4th July 2013

Application for Householder Planning Permission

Development Ground floor kitchen and lounge extension with 1st floor bedroom extensions over.
Location Meadowsweet Summer Lane Pagham

Scale	A.H.	@ A3	Drawn By	
Date	MAY 13.		Checked	
Drawing Number			4924-1

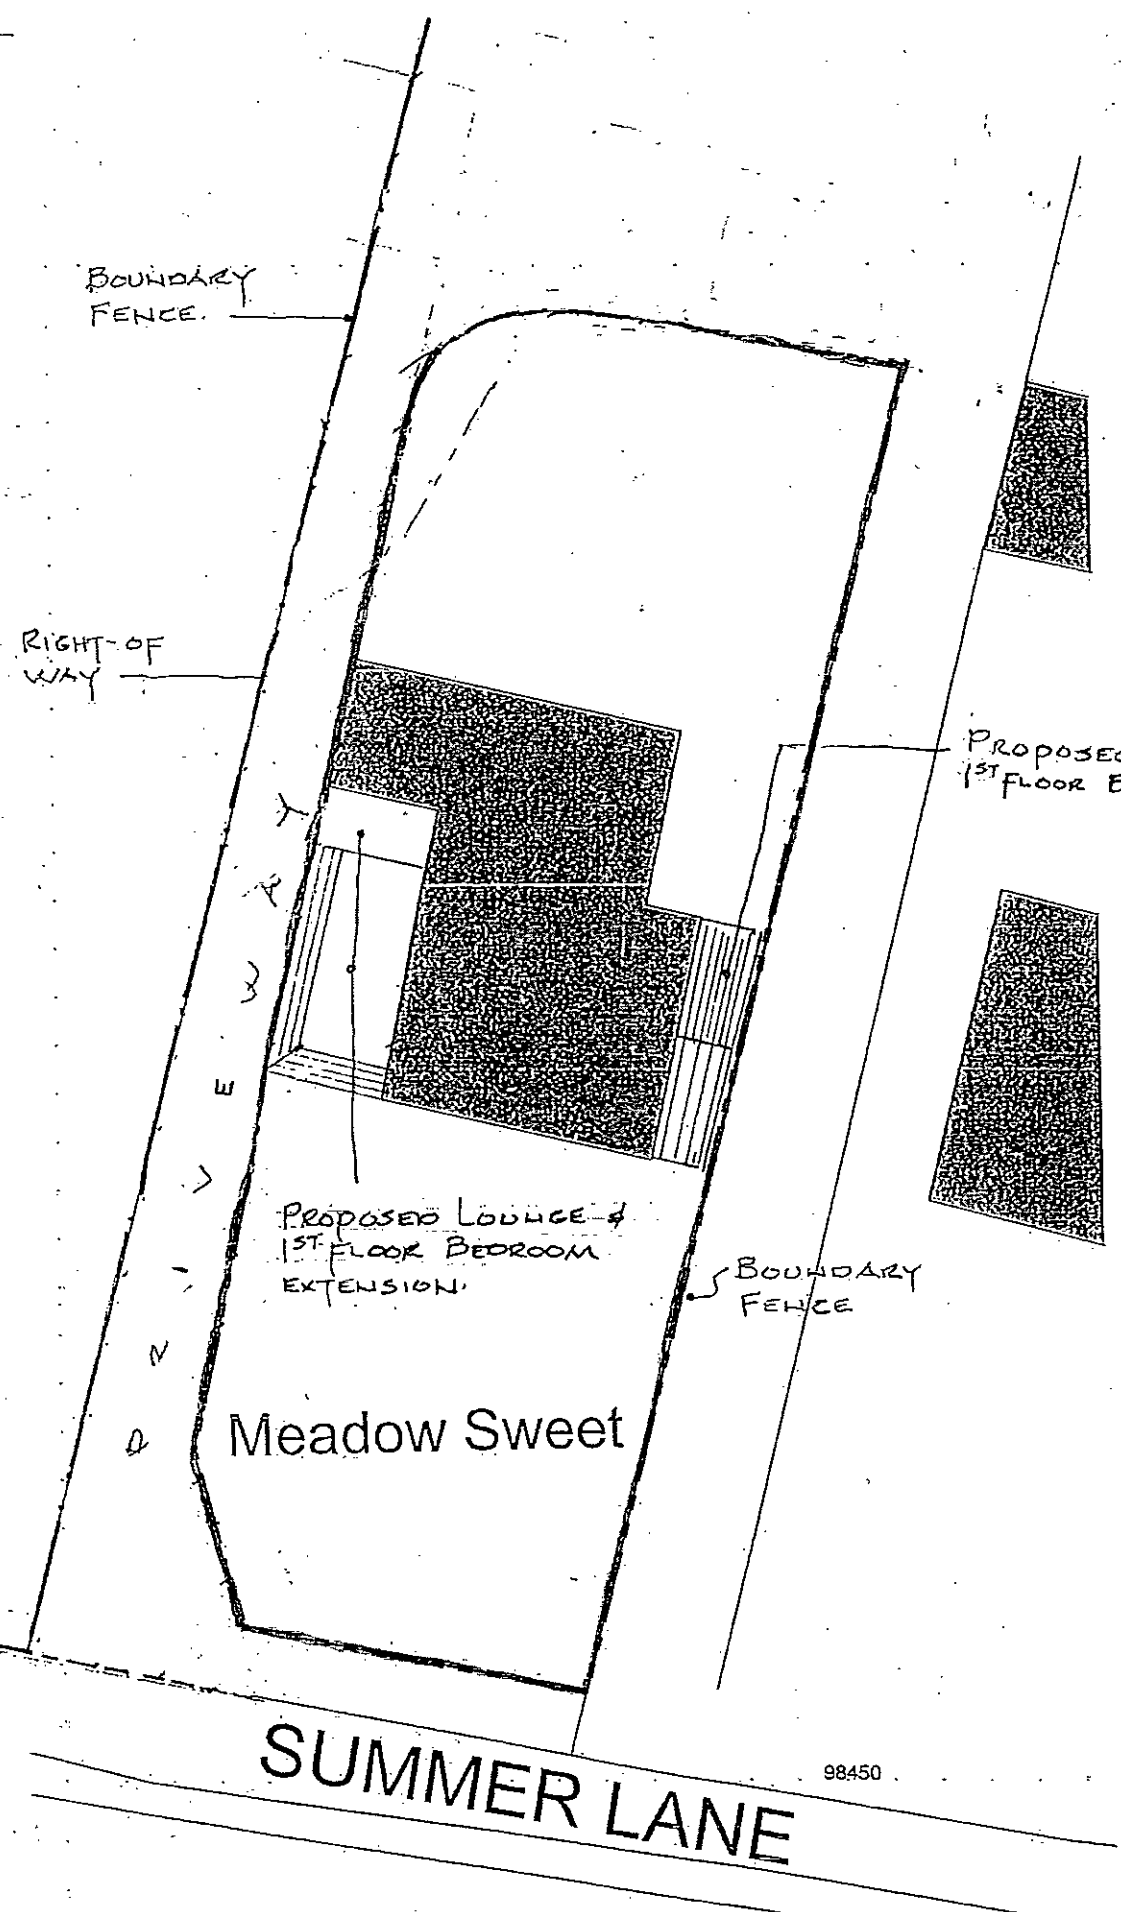
Please submit 1 electronic or 3 paper copies of a revised location plan with the site red edged in accordance with the guidance notes available on our website detailed below (click on National List).
